918 Brighton Avenue | Portland, Maine 04102

January 3, 2013

**RE: Response to City Review Comments  
Level I Site Plan Development Review Application  
Motley Street Extension, Portland, Maine**

C2.0

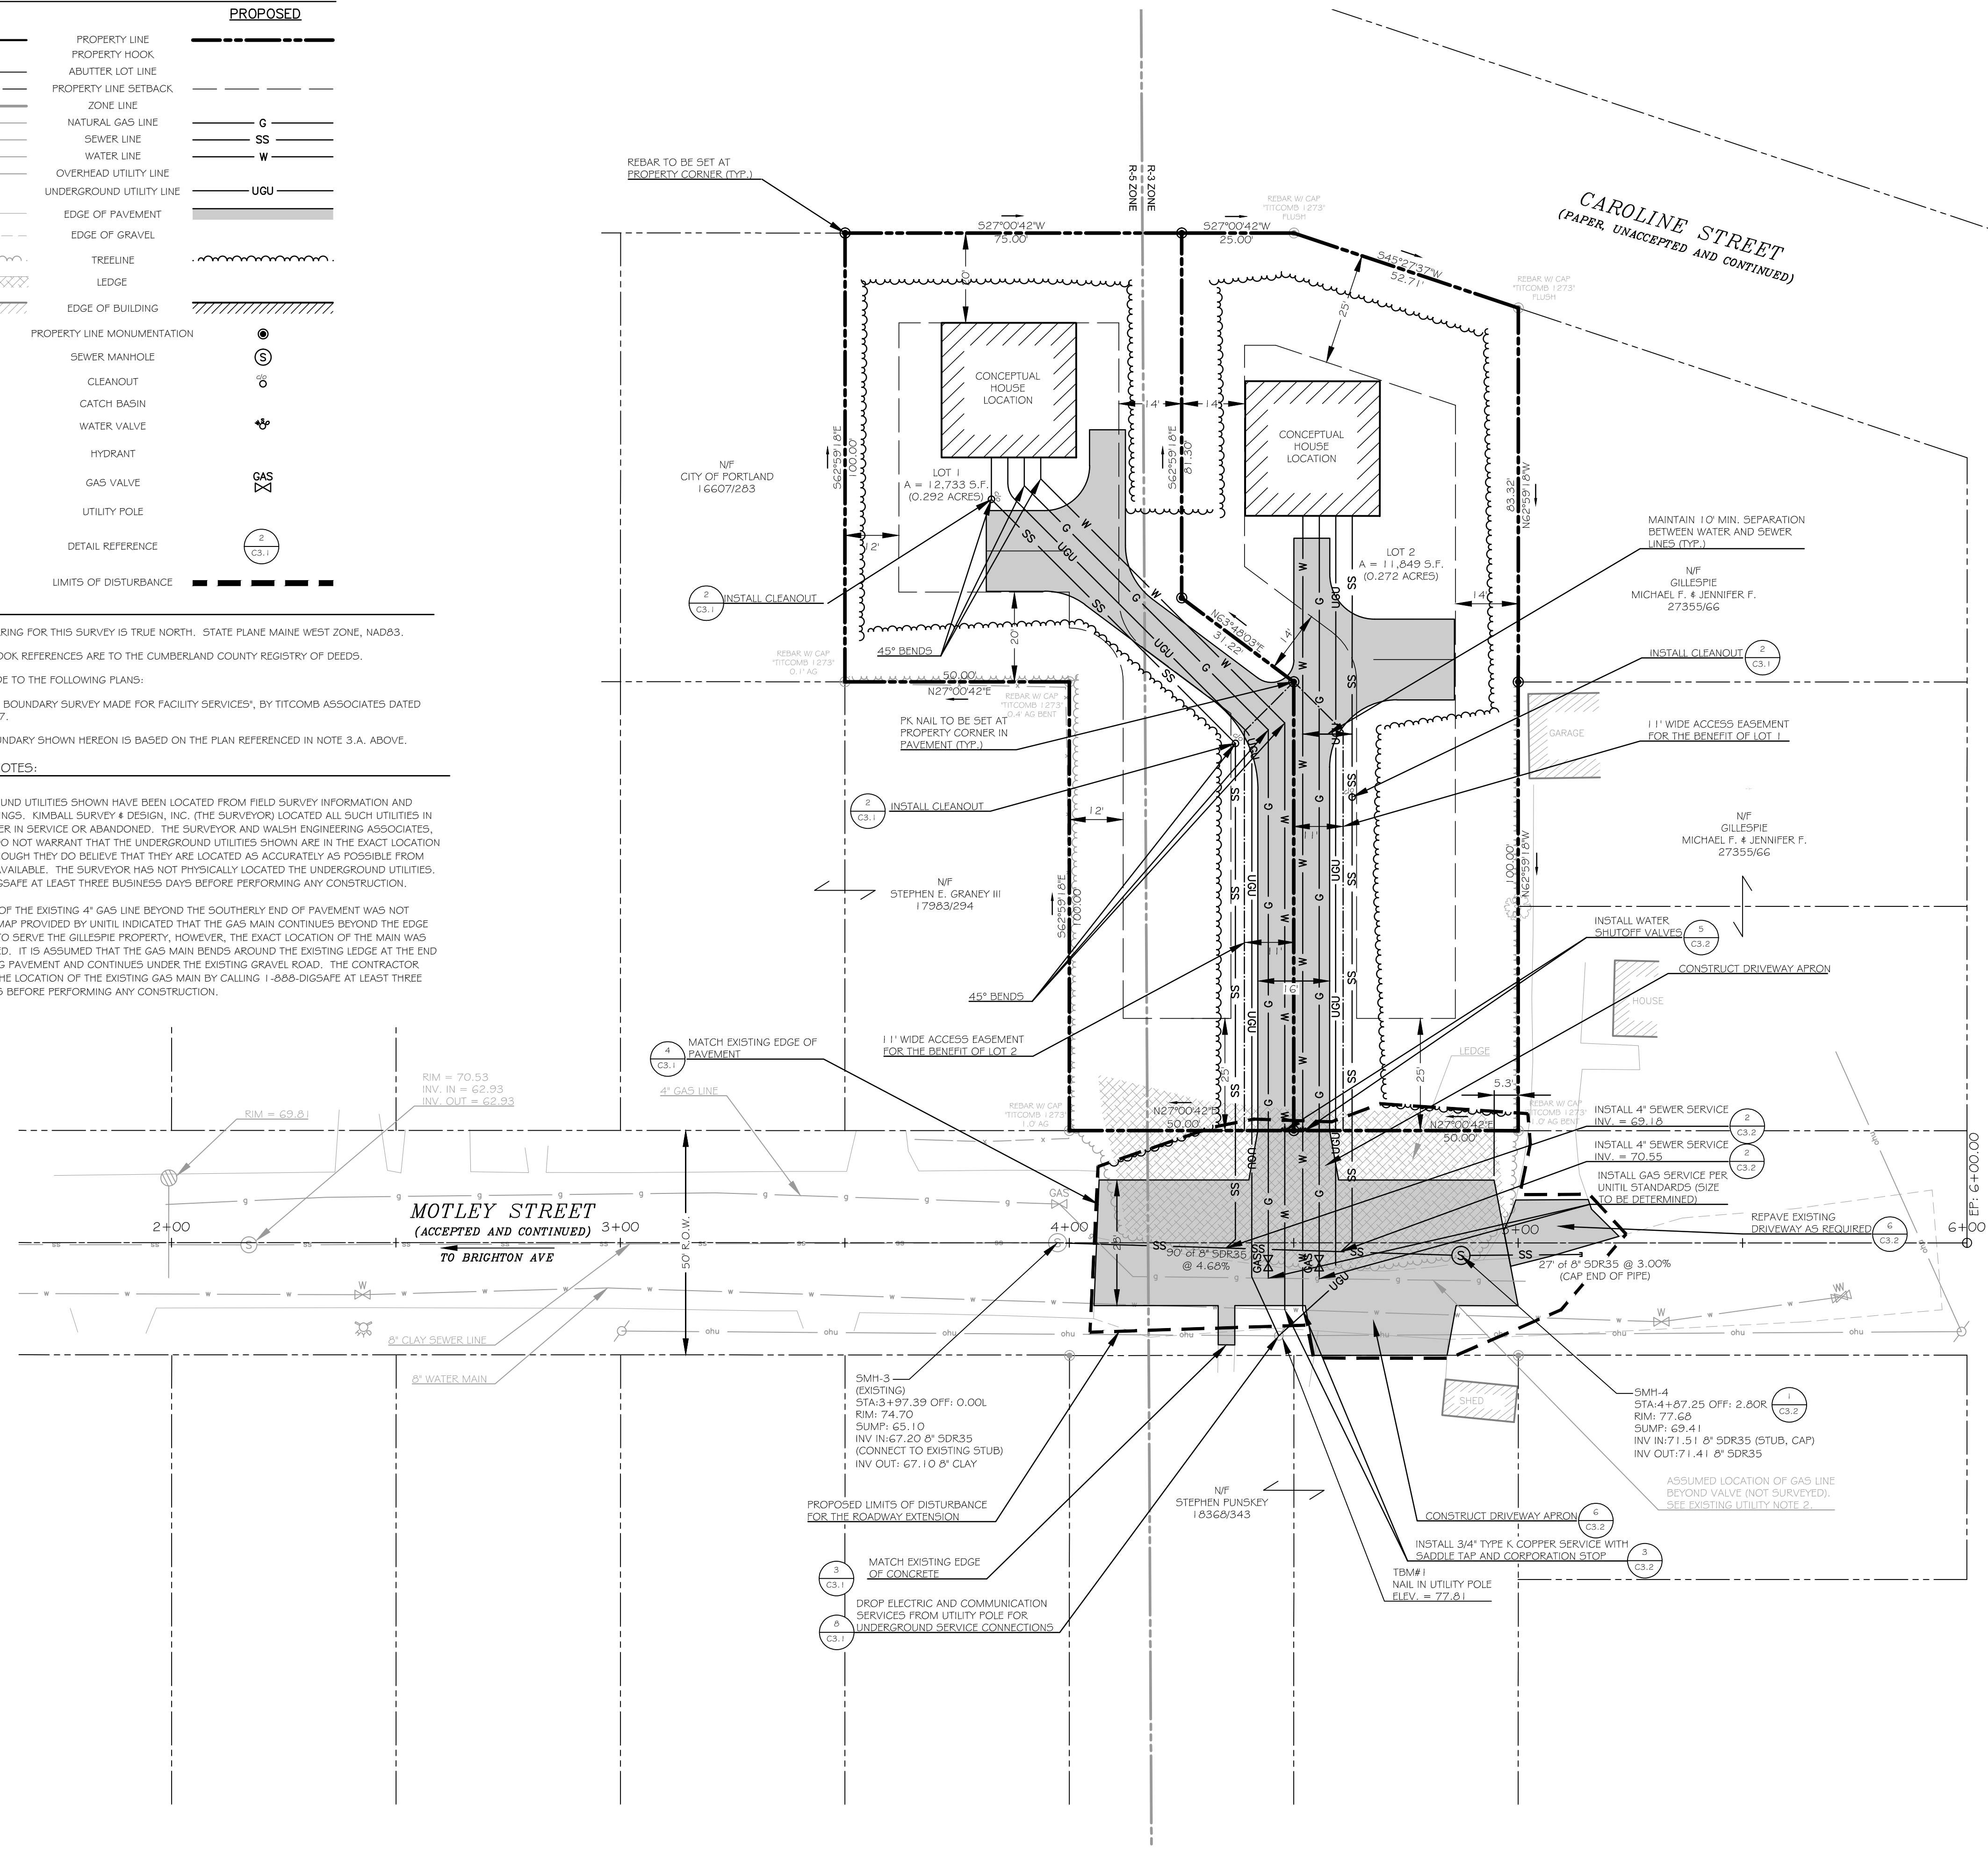
Walsh Engineering Associates, Inc. has reviewed section 3.7 of the City's Technical Manual and has added a note to sheets C.2.0, C2.1, and C3.0 that a blasting permit and all associated submittals will be required for a "large blast" operation (removal of greater than 300 c.y. of rock material).

Job No.:	173	Sheet No.:	C2.1
Date:	NOV 9, 2012	Scale:	1" = 20'
Drawn:	SWC	Checked:	WRW

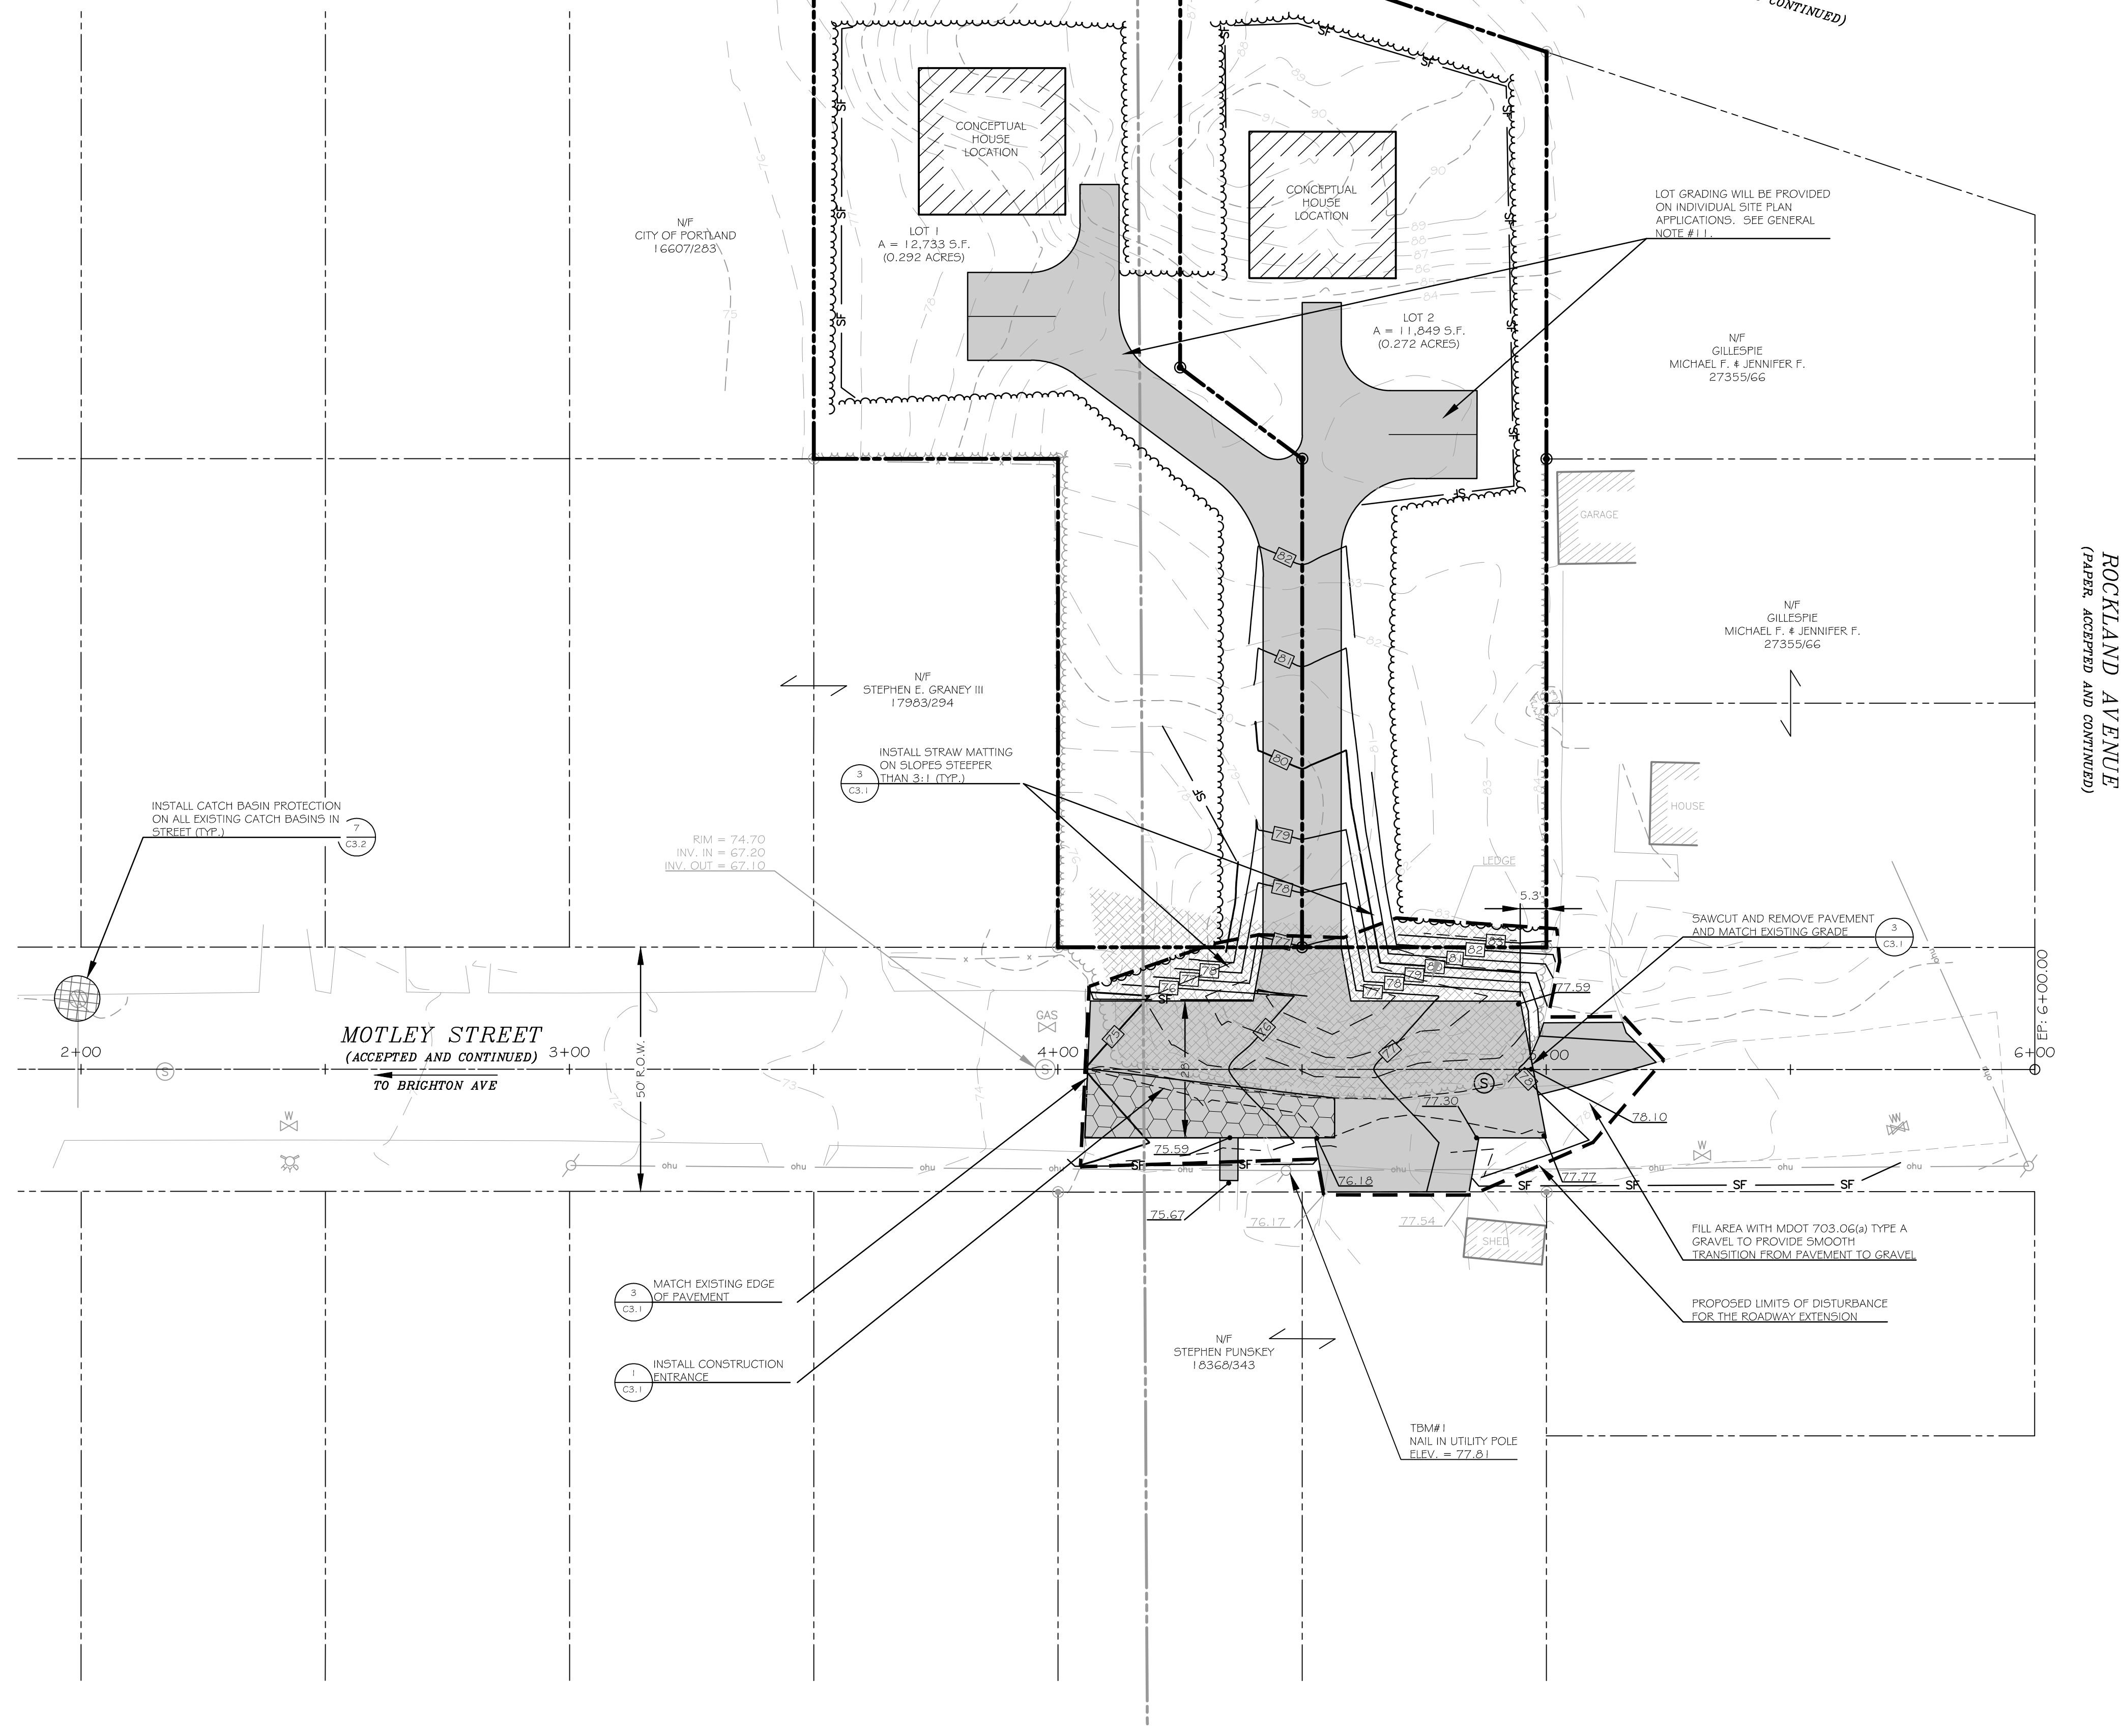
Catch basin inlet protection provisions have been added to the site plans. A symbol and leader note have been added to sheet C2.1 and the appropriate detail has been added to sheet C3.2 (detail #7).
